KITTITAS COUNTY

MEMORANDUM

TO: All Staff
FROM: Public Works Plan Review Team
DATE: December 23, 2025- January 14, 2026 UPDATE
SUBJECT: BL-25-00020 Martin

RECORD OF SURVEY

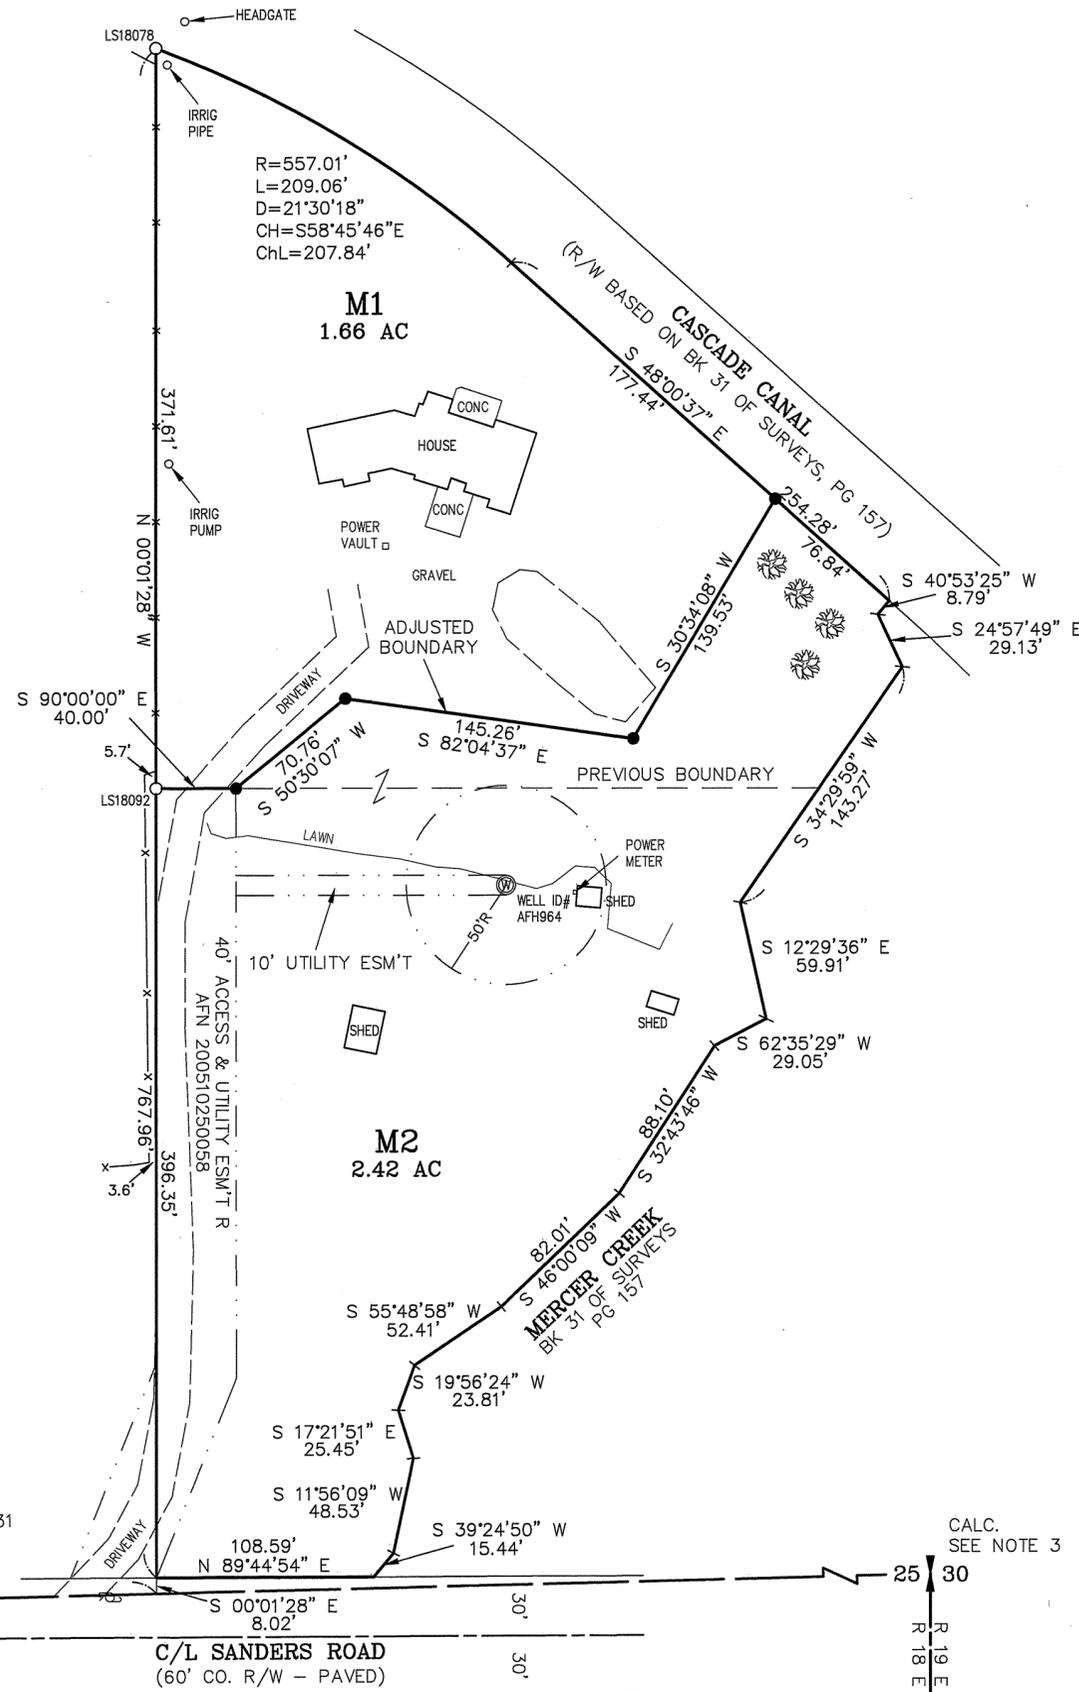
ENGINEERING	1. Except as exempted in KCC 14.05.060, no grading or filling upon a site involving more than one hundred (100) cubic yards shall be performed without a grading permit from the County Engineer or Public Works designee (KCC 14.05.050). An application for grading in excess of five hundred (500) cubic yards shall be accompanied by an engineered grading plan (KCC 14.05.080). 2. Additionally, Kittitas County Code 12.07 requires use of City of Ellensburg standards for roadways and utilities within the UGA. (CBP)
SURVEY	Will hold comments until final survey documents are provided. (DF) UPDATE 01/14/2026 1. Please identify dashed area located in the SE portion of Parcel M1. 2. The dimension of '254.28' located on the SW boundary of canal is obscured by a symbol. (JT)
